Anita Gardner
Principal Planning Officer,
Directorate of Place

Dear Mr Rogers,

I have received the following comments from the environmental health officer.

## Proposed Ground Floor Plan

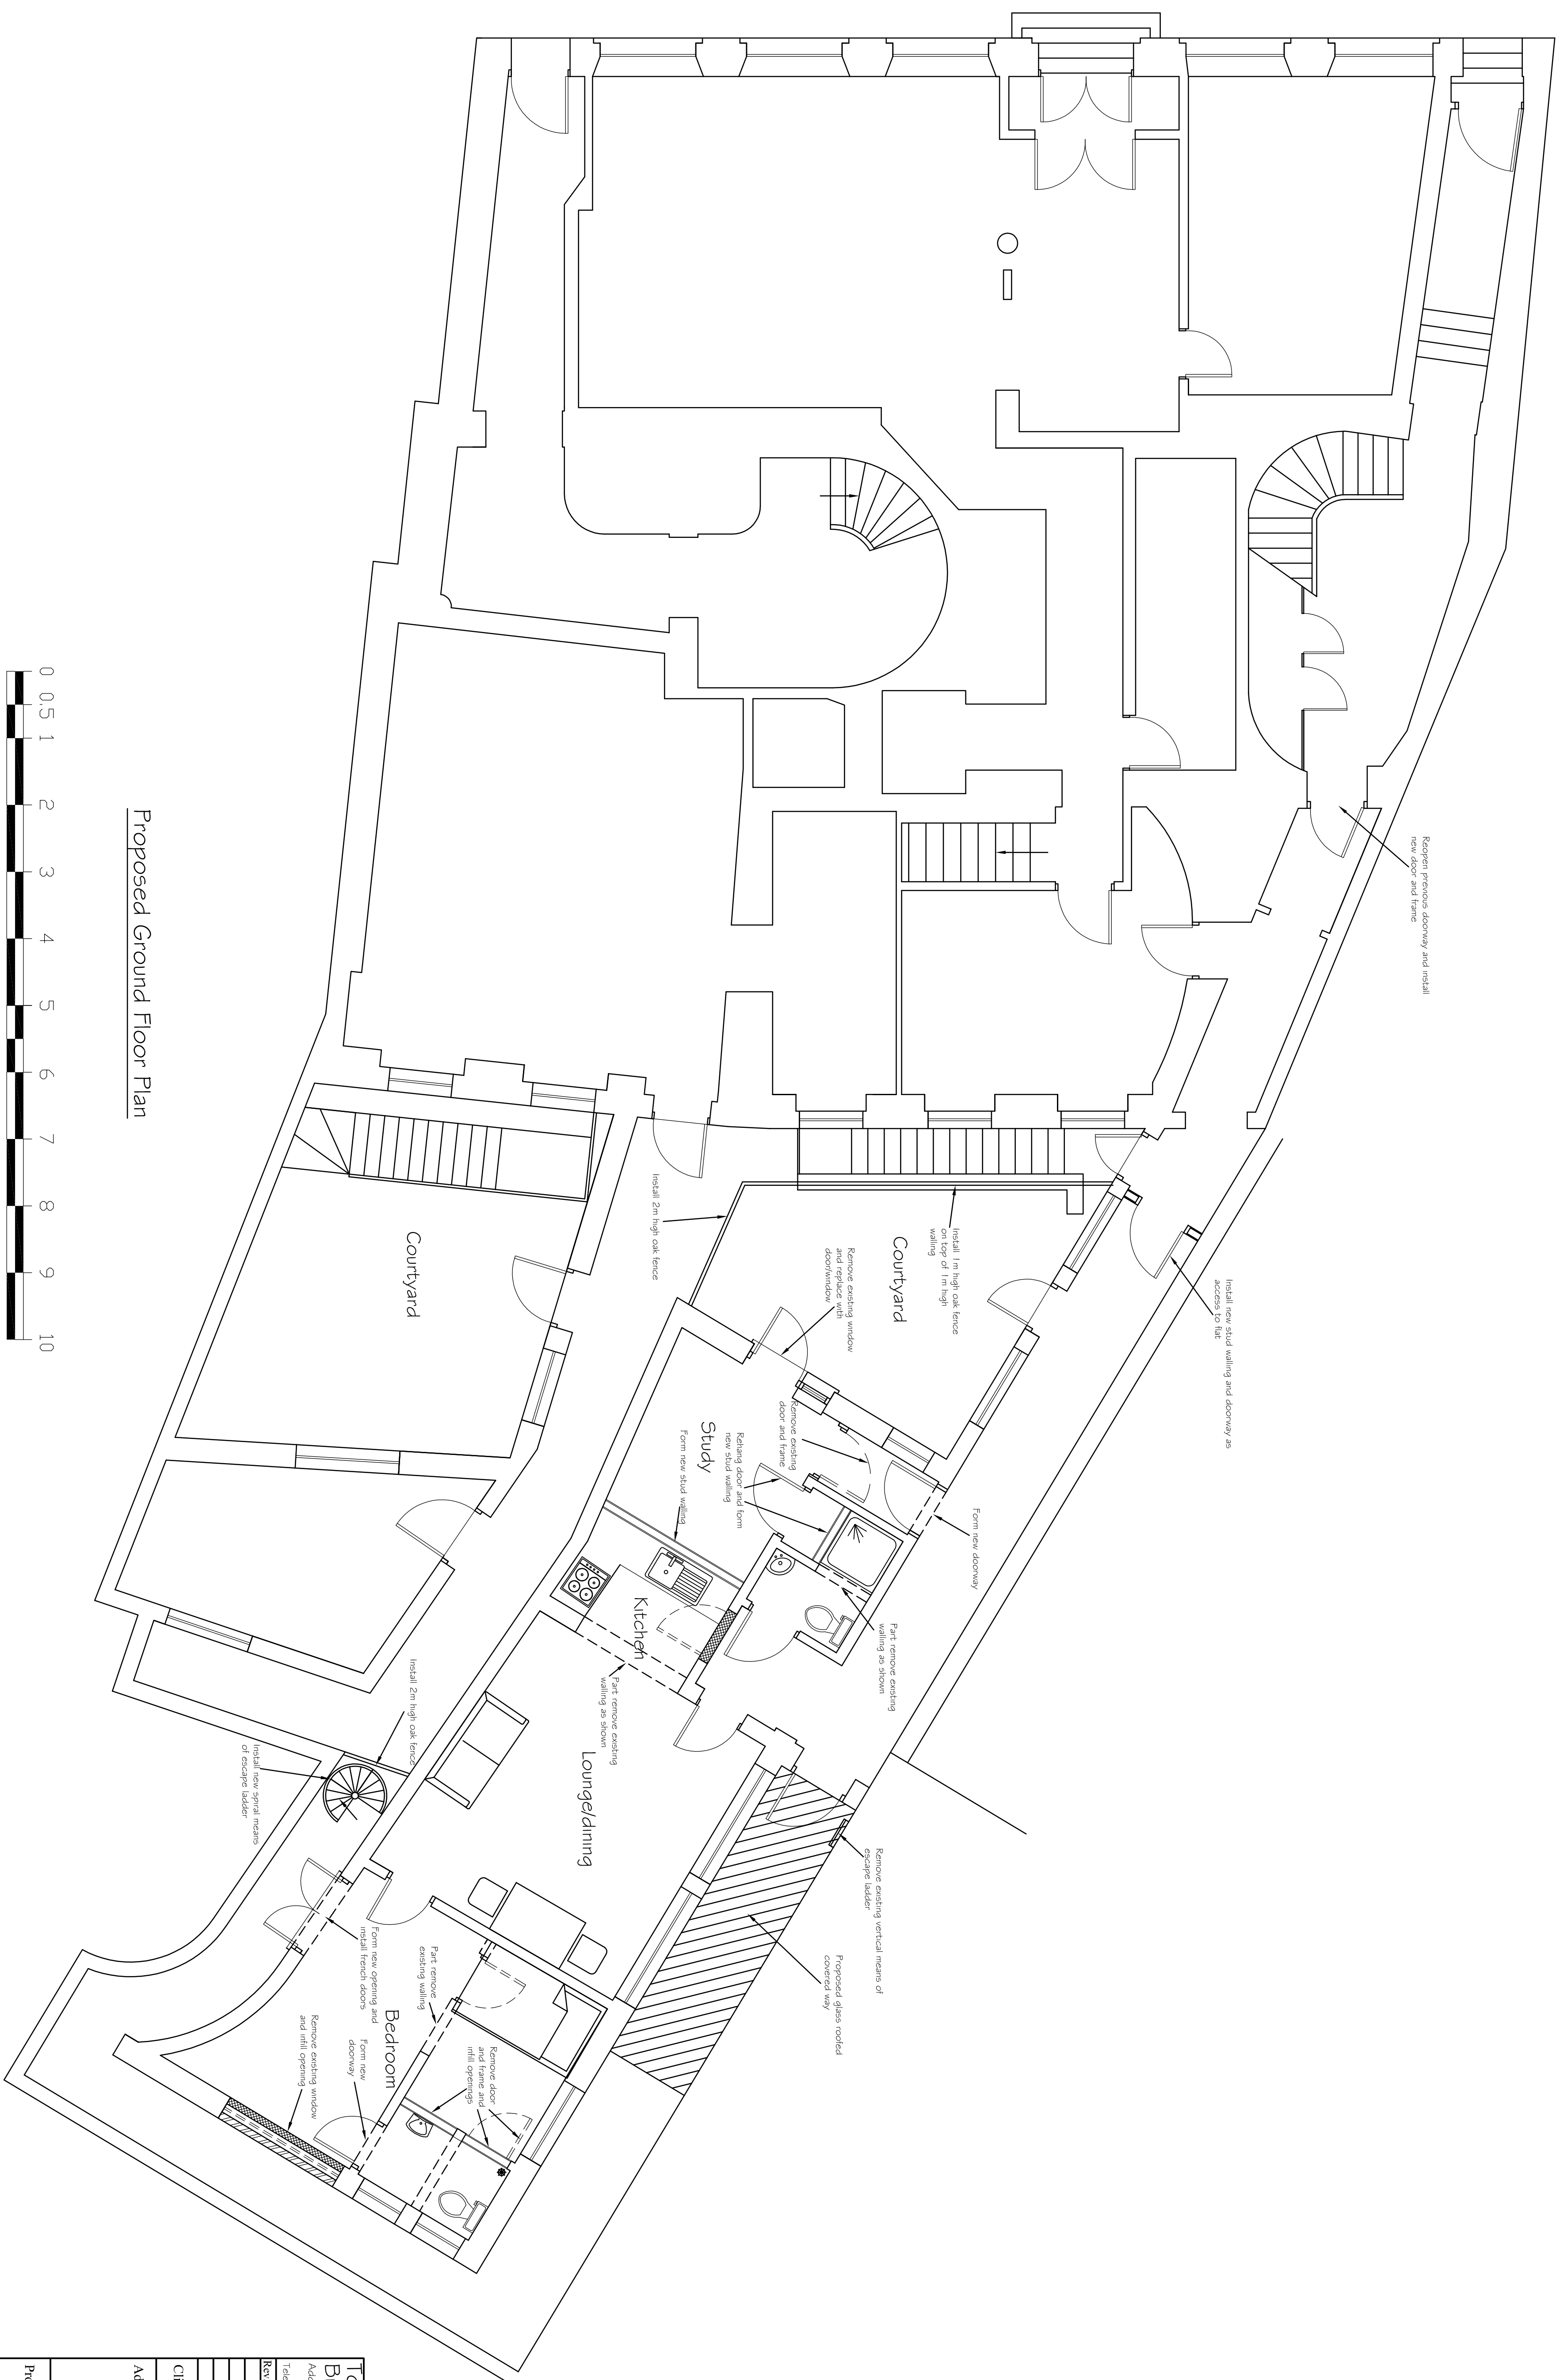
‘One of the photographs shows an air conditioning unit in very close proximity and pointing directly towards the windows of the planned dwelling. This has the potential to negatively affect the residential amenity of any future occupiers by causing noise and vibration issues. However, the plans indicate that it is proposed to put a glass roof over this

area. I would therefore need to know what this air conditioning unit serves and if it is to be left in place, totally removed, replaced or moved somewhere else and if so where to before I would be confident that there will not be a noise issue. I would ask that the applicant provides answers to the above issues so that I can make a full assessment. Without this information I would have to consider objecting to the application on noise grounds or requesting a noise assessment and potentially sound insulation works in order to ensure that any future occupiers are not disturbed by noise from the unit.’
